DELEGATED HOUSEHOLDER DECISION

Item No.	Report of the Head of Development Management and Building Control	
Address:	3 WOODVILLE GARDENS RUISLIP	
Development:	Conversion of roof space to habitable use to include a rear dormer, 3 front roof lights and conversion of roof from hip to gable end x 2.	
LBH Ref Nos:	78426/APP/2023/3512	
Drawing Nos:	P1432-01 Location & Block Plans P1432-02 Existing Ground Floor Plan, Roof Plan and Elevations P1432-03 Proposed Ground Floor Plan, Loft Plan and Elevations	
Date Plans received:	04-12-23	Date(s) of Amendments(s):
Date Application valid	04-12-23

Drawing Title:
 PROPOSED PLANS AND ELEVATIONS

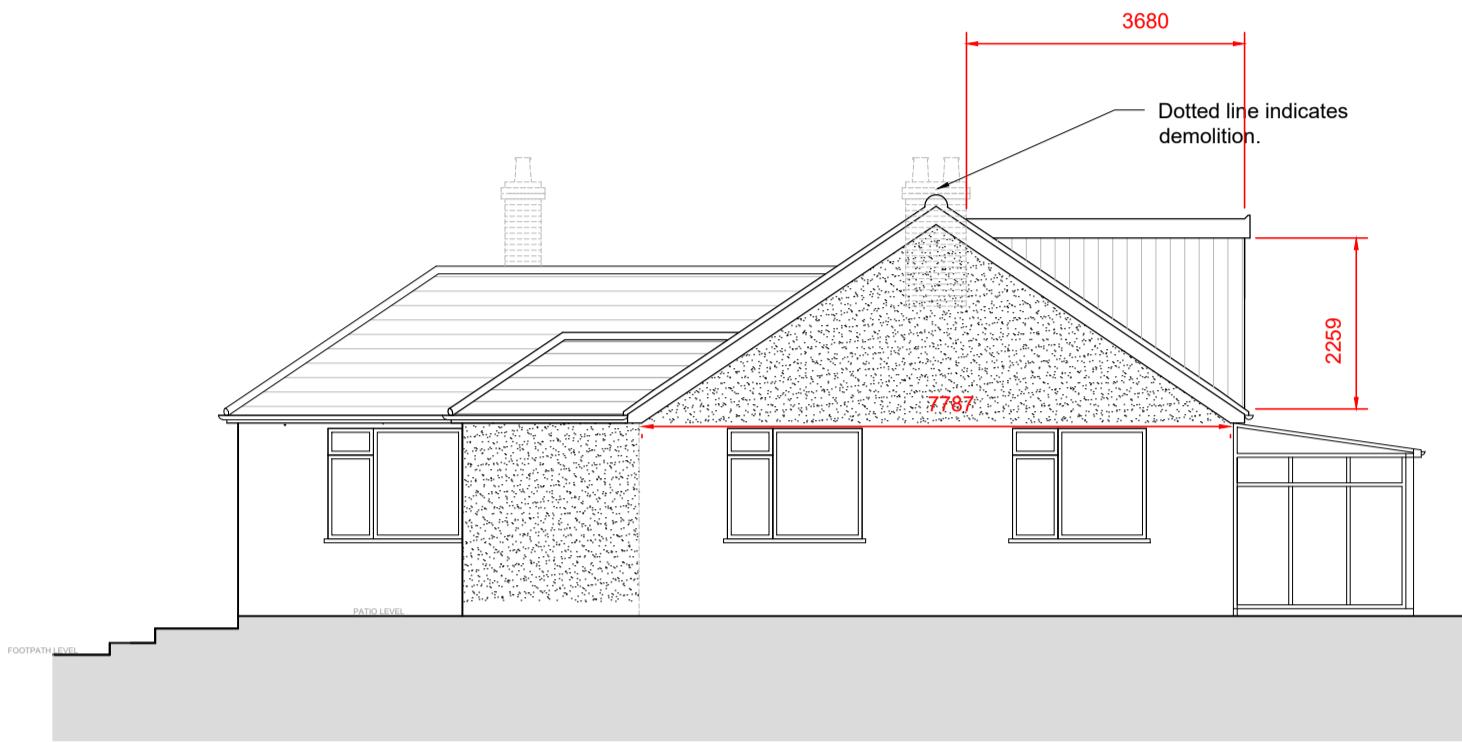
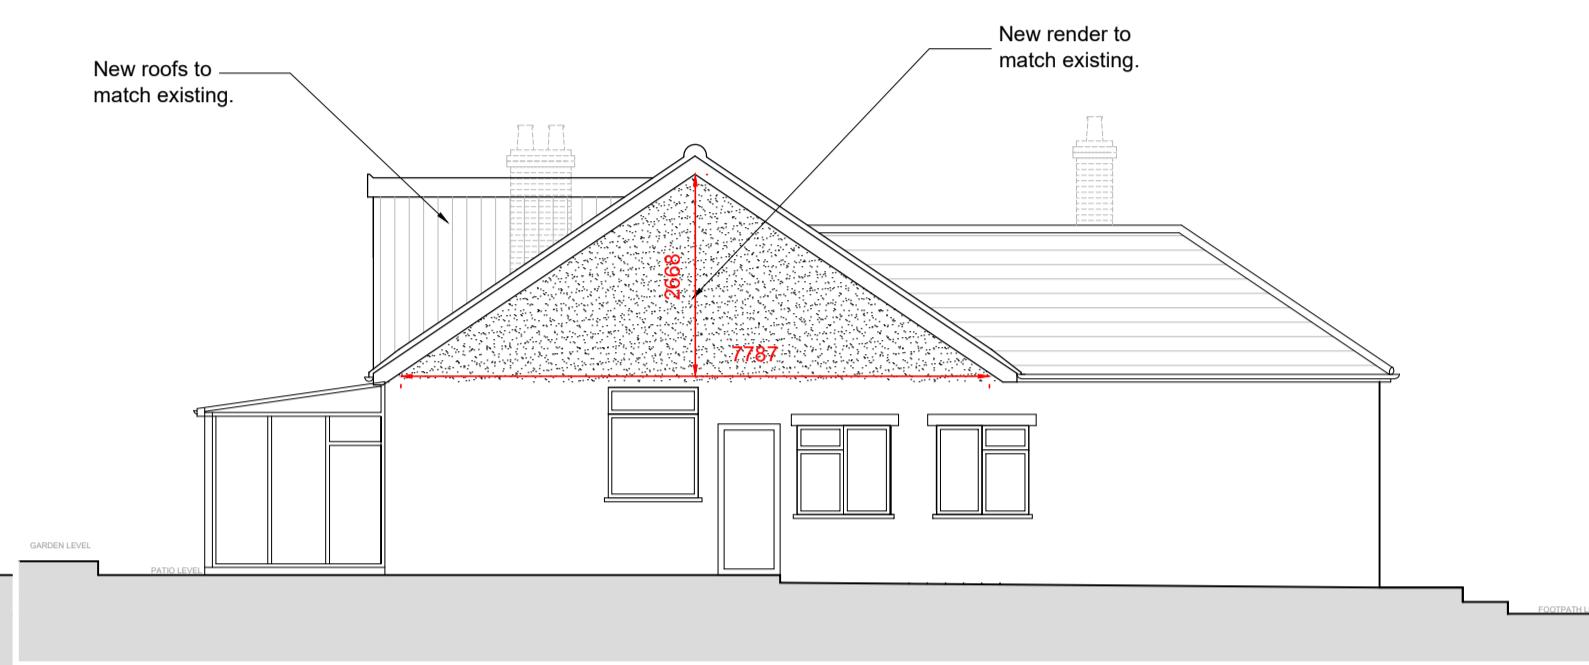
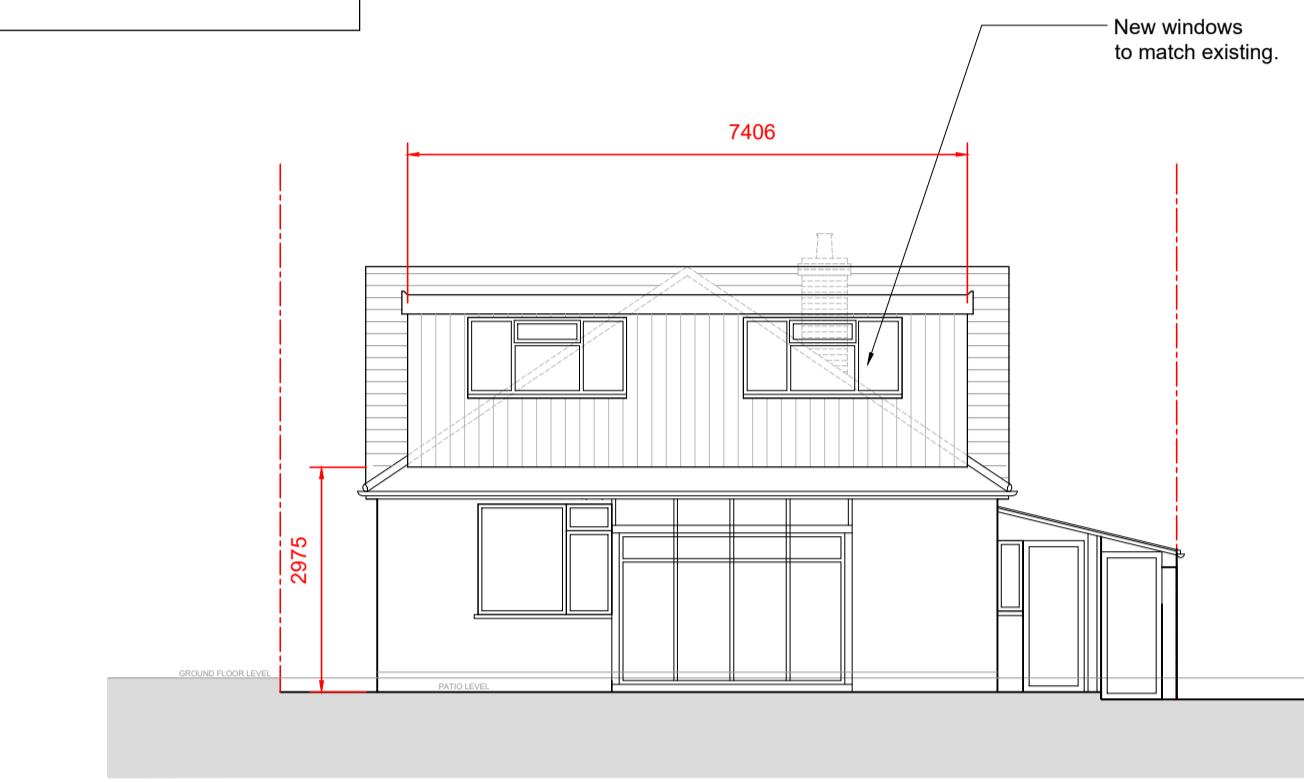
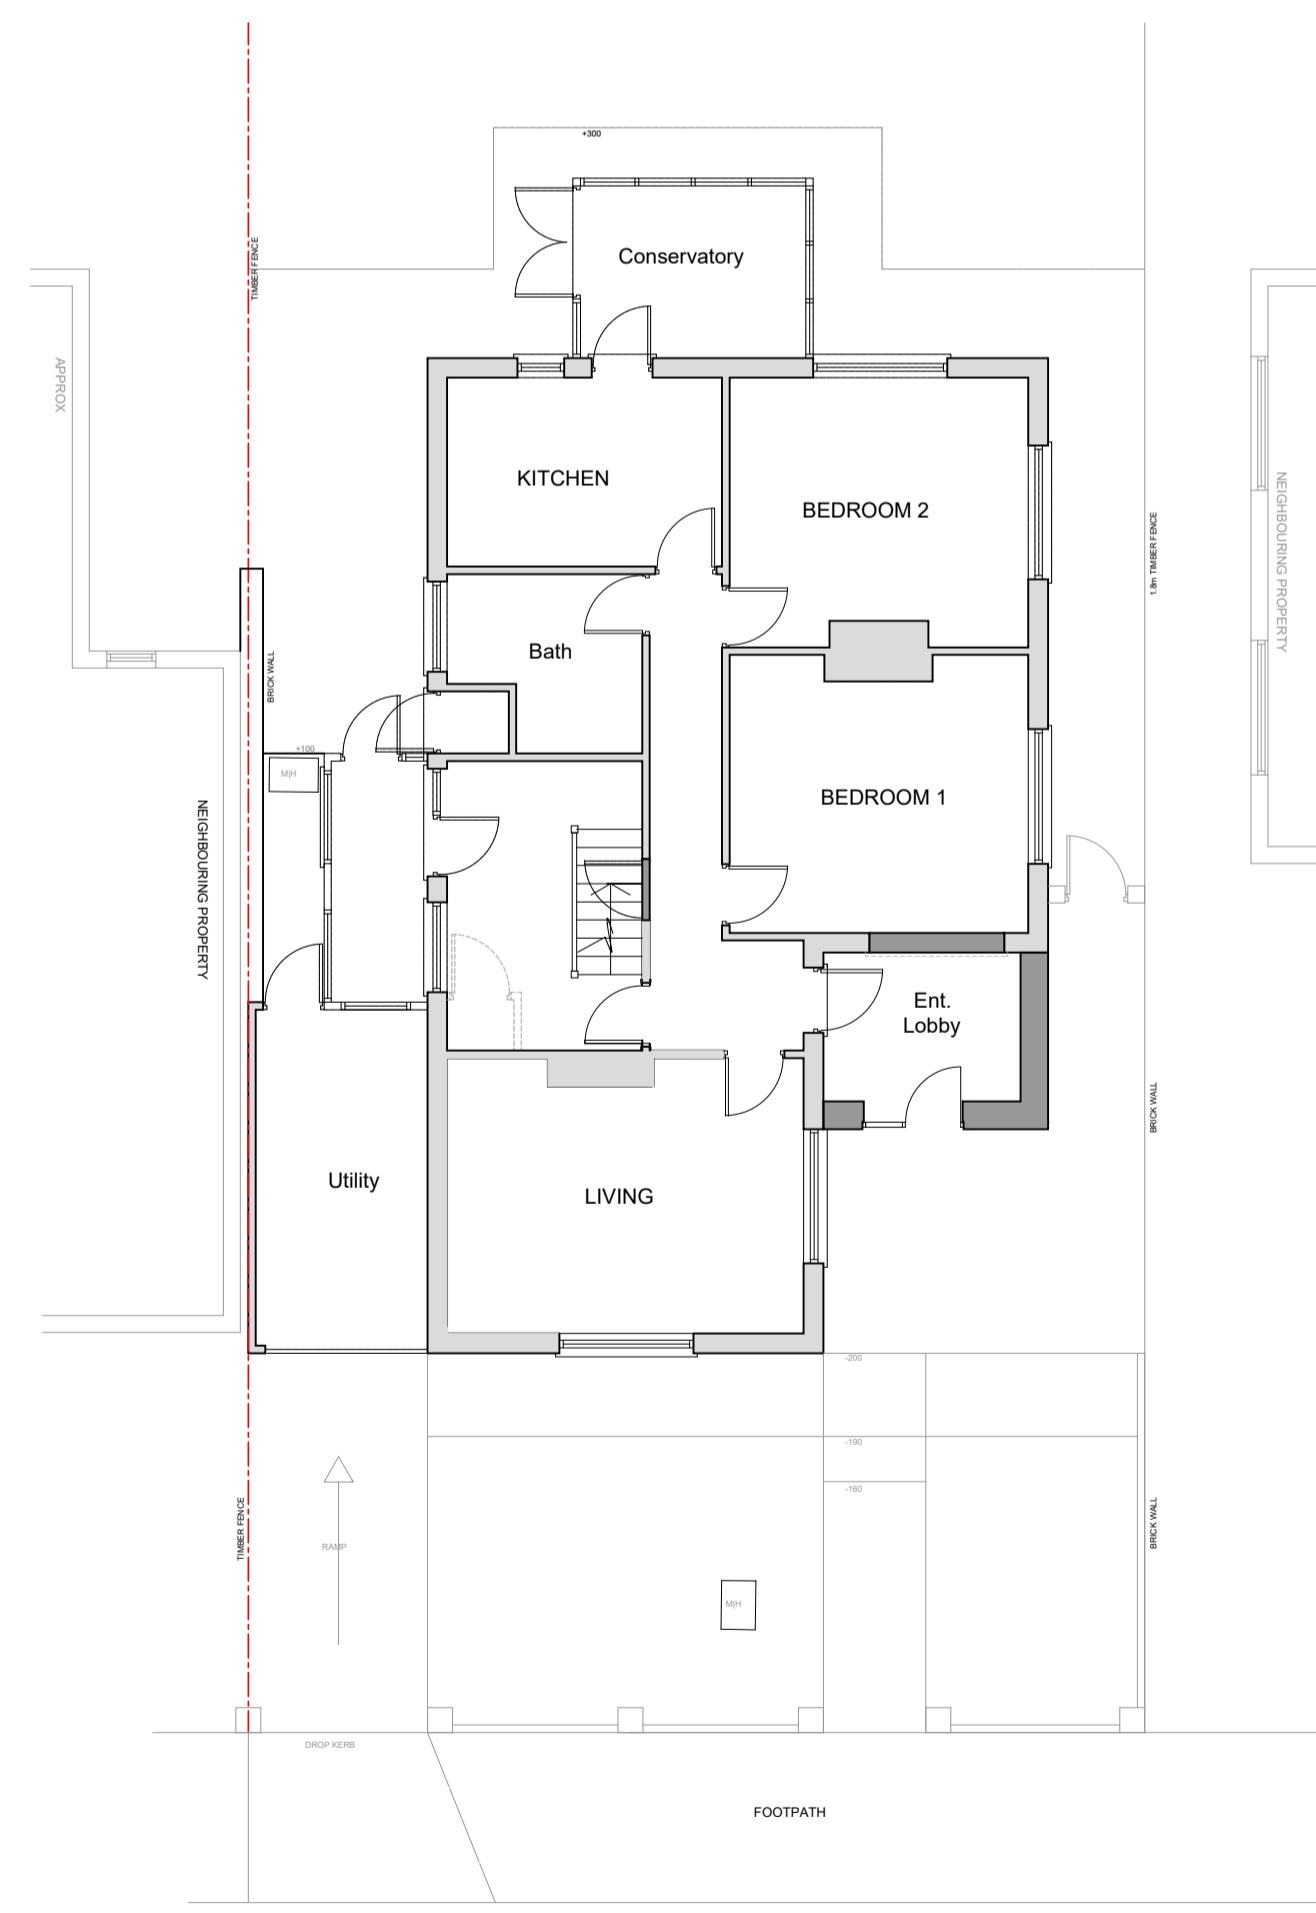
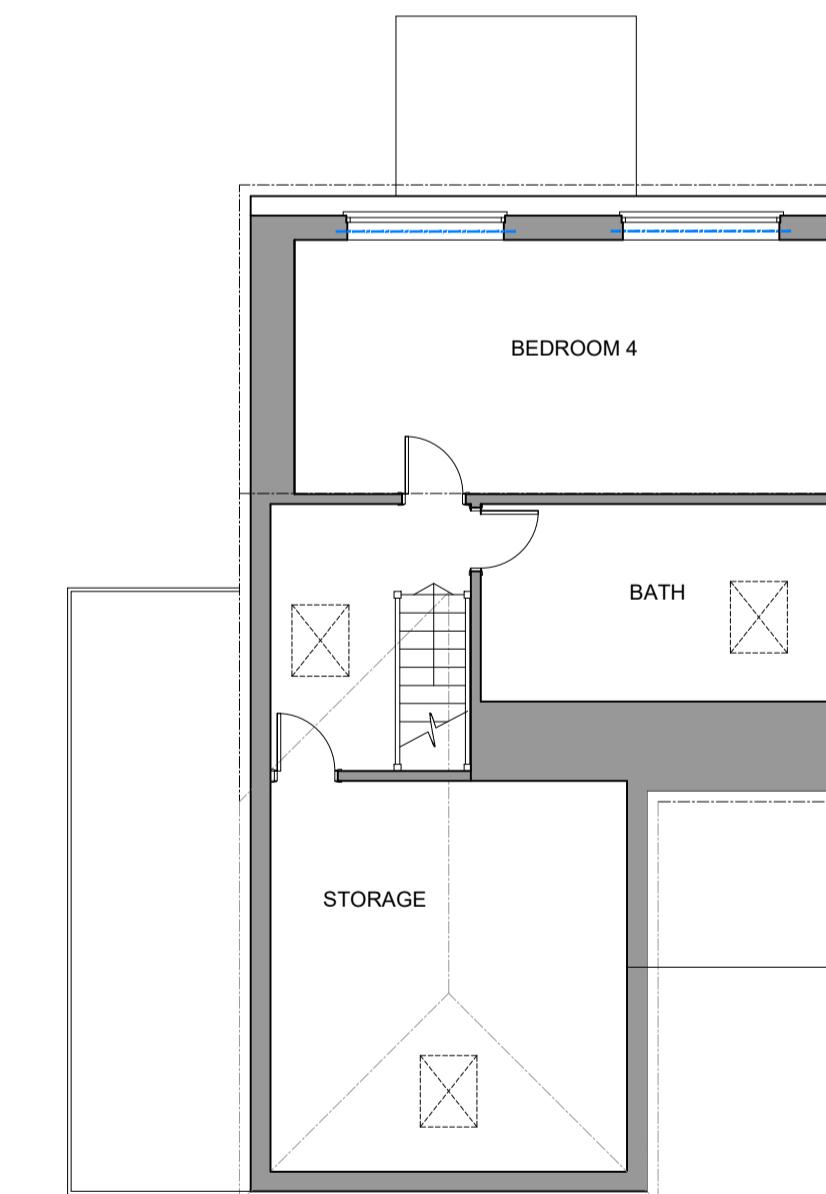
The proposal fails to comply with the requirements of Policy DMHD1 of the Hillingdon Local Plan: Part Two - Development Management Policies (January 2020). The proposal, which includes two

hip to gable end conversions and a large rear dormer would substantially alter the appearance of the property which would be visible from public viewpoints. The significant increase in the overall size, scale, bulk and massing of the host dwelling would result in a development that would not appear subordinate or harmonise with the roof of the existing dwelling. The application property is a detached bungalow with neighbouring detached bungalows either side and there are other detached bungalows within the surrounding area; it is noted that a number of detached bungalow have habitable accommodation within the roof space although these have smaller dormer windows within the front roof slope or small roof alterations/rooflights. As a result, the proposed hip to gable end conversions and rear dormer would appear out of keeping with the character and appearance of the surrounding area.

It is therefore considered that the proposed hip to gable end conversions and rear dormer would be unduly prominent, visually incongruous and unsympathetic to the original architectural composition of the host dwelling. As such, the proposed hip to gable end conversions and rear dormer would have a detrimental impact on the character and appearance of the original dwelling, and on the character and appearance of the immediate street scene and the surrounding area.

The proposed hip to gable end conversions and rear dormer, by reason of their size, scale and bulk, would be unduly prominent, visually incongruous and unsympathetic to the original architectural composition of the host dwelling, resulting in a detrimental impact on the character and appearance of the original dwelling, and would be out of keeping with the character and appearance of the immediate street scene and the surrounding area. The proposal thereby fails to comply with Policy BE1 of the Hillingdon Local Plan: Part One- Strategic Policies (November 2012), Policies DMHB 11, DMHB 12 and DMHD 1 of the Hillingdon Local Plan: Part Two - Development Management Policies (January 2020), Policies D3 and D4 of the London Plan (March 2021) and Chapter 12 of the National Planning Policy Framework (December 2023).
